DRB CASE ACTION LOG (SITE PLAN B.P.)

DRB Application No.: 05DRB-00886 (SBP)
Project Name LADERA INDUSTRIAL PARK
Agent: Jim Miller & Associates

Site Plan for BP

SITE PLAN, NOTES AND DETAILS

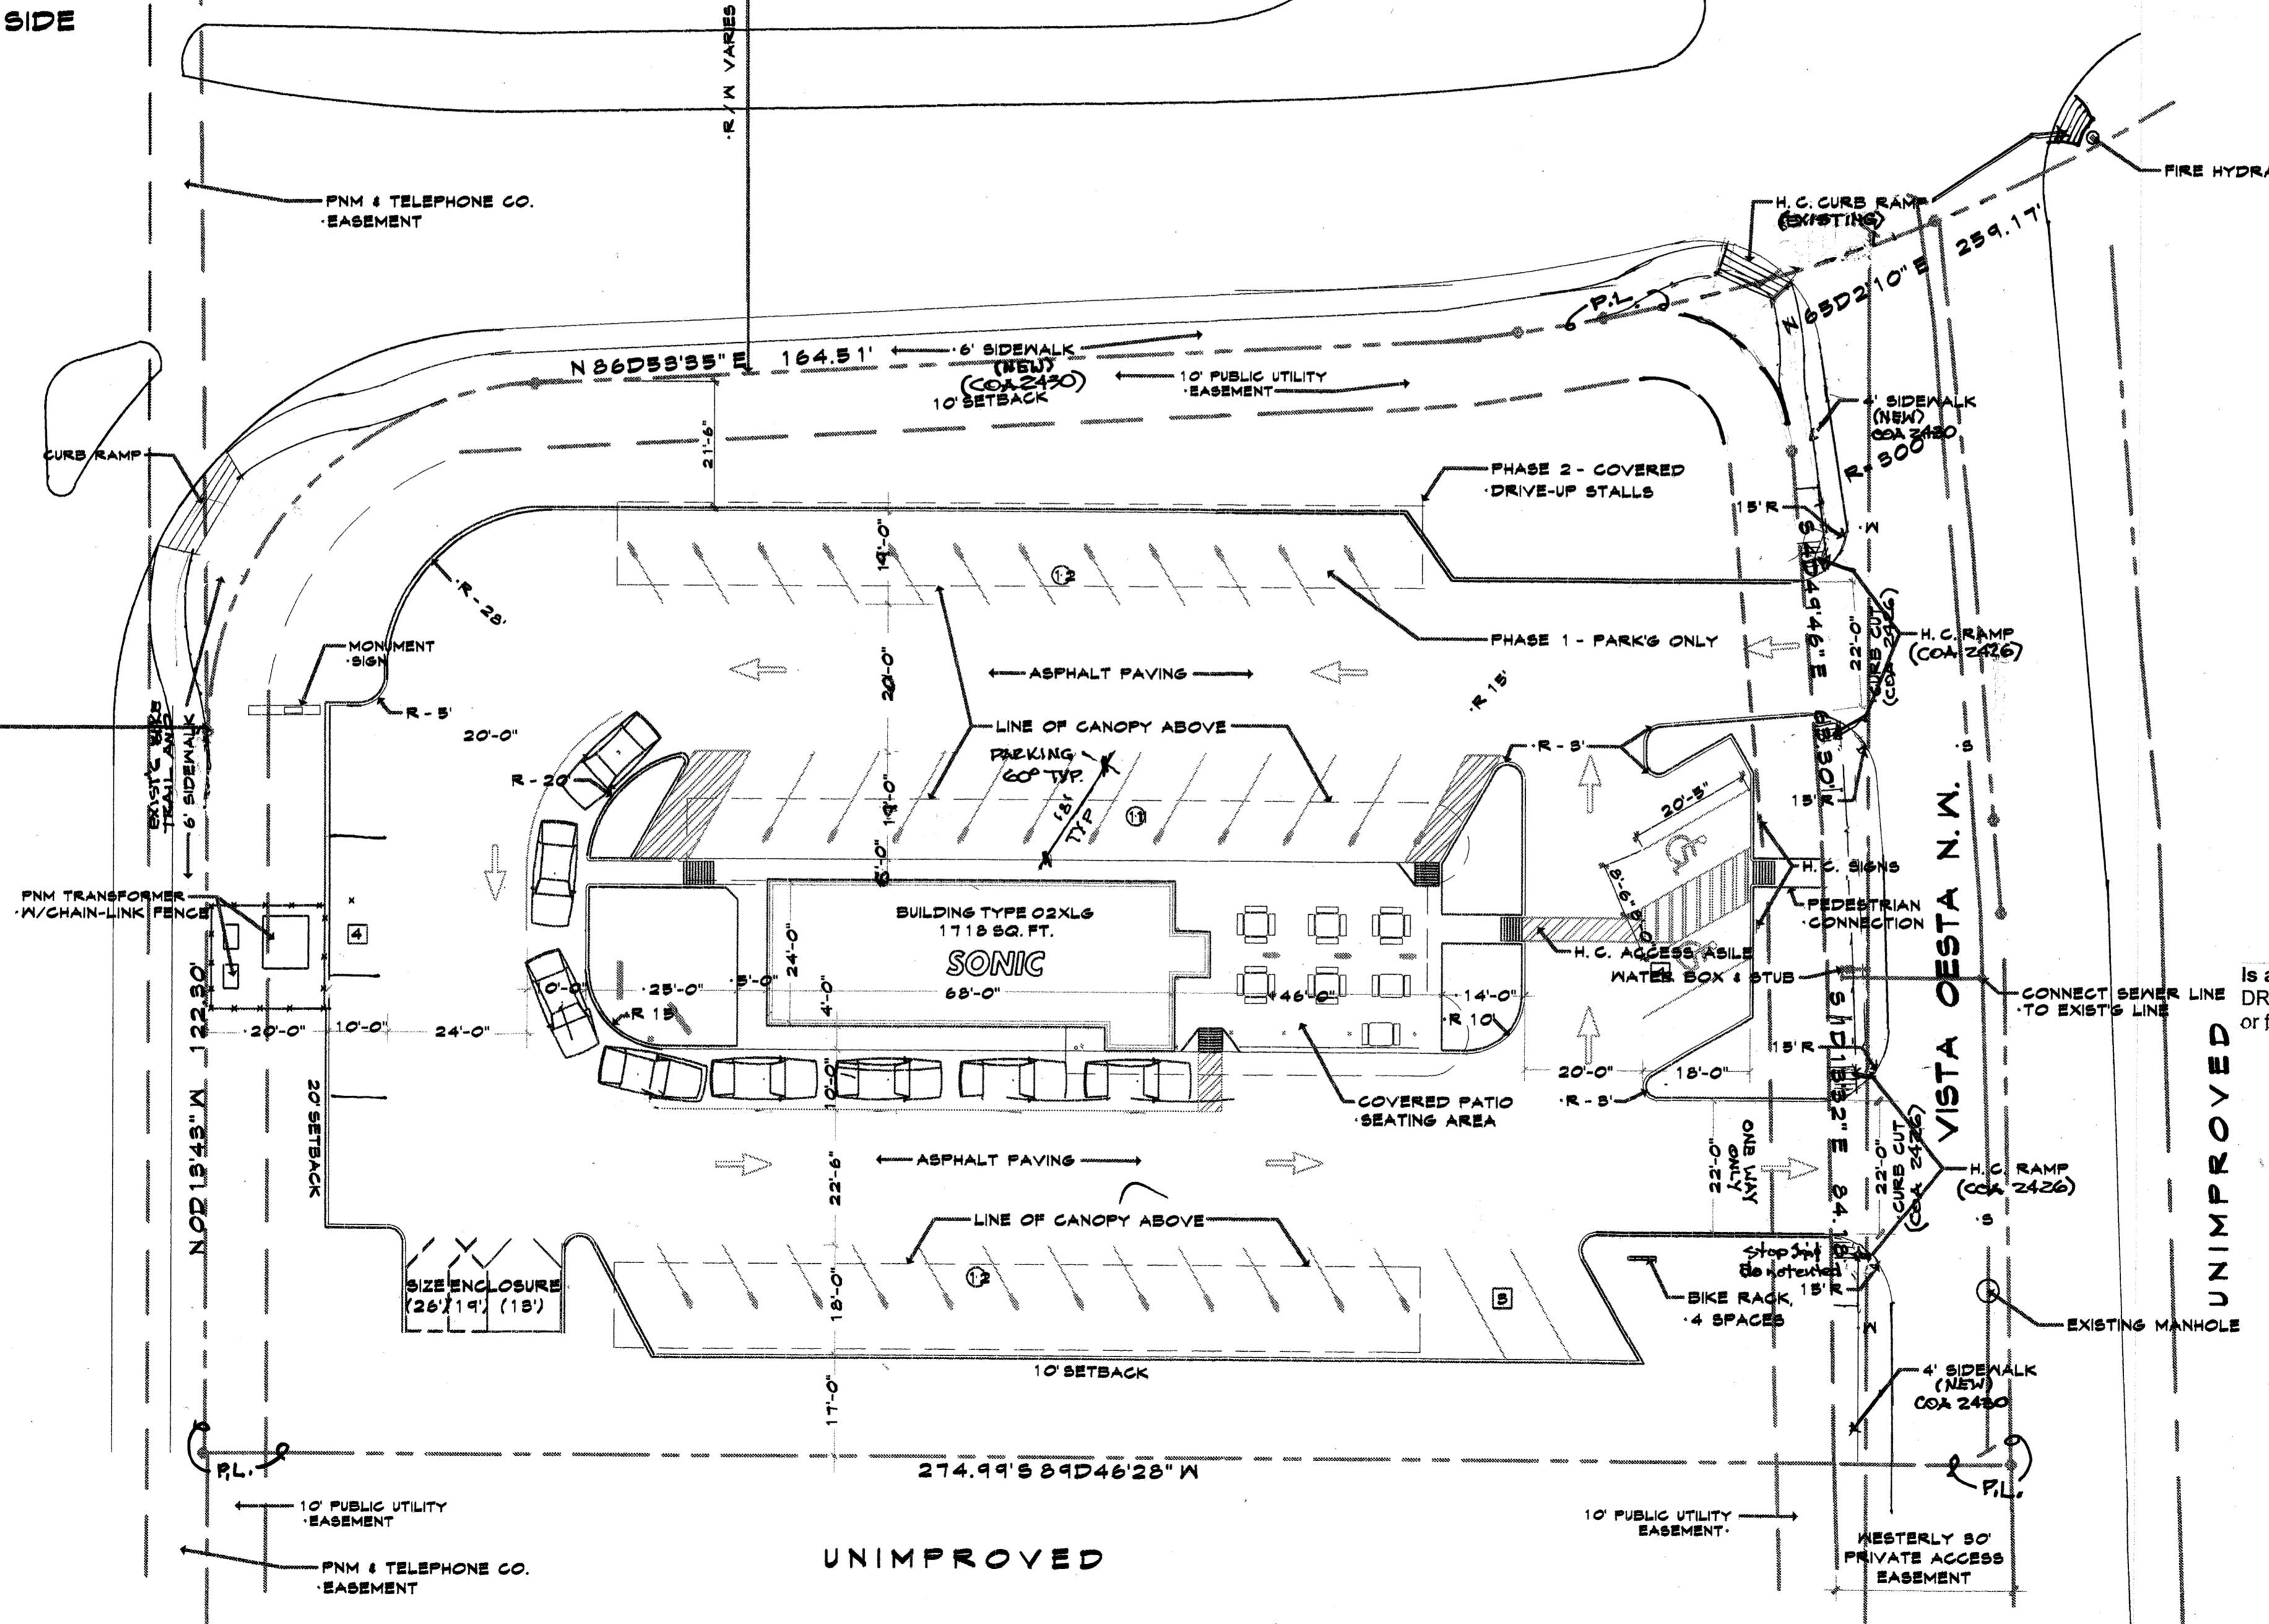
- TRANSPORTATION: 3 copies of SPBP
DIMENSIONING ! CITY STANDARD DIMS NEEDED
- UTILITIES:
- CITY ENGINEER / AMAFCA: SIA
- PARKS / CIP:
- PLANNING (Last to sign): 3 copies of SPBP

JIM MILLER agent(s) for JOHN WILGER request(s) the above action(s) for all or a portion of Lot(s) 19, **LADERA INDUSTRIAL PARK, UNIT 2**, zoned SU-1, located on 98TH STREET NW and UNSER BLVD NW and containing approximately 2 acre(s). [REF: Z-92-45, 01EPC01405, Project 1001523] [Listed under Project 1004096 in error] [Deferred from 6/1/05] (H-9) **WITH THE SIGNING OF THE INFRASTRUCTURE LIST DATED 6/8/05 THE SITE PLAN FOR BUILDING PERMIT WAS APPROVED WITH FINAL SIGN OFF DELEGATED TO CITY ENGINEER FOR SIA AND TRANSPORTATION DEVELOPMENT FOR DIMENSION LABELING AND 3 COPIES OF THE SITE PLAN.**
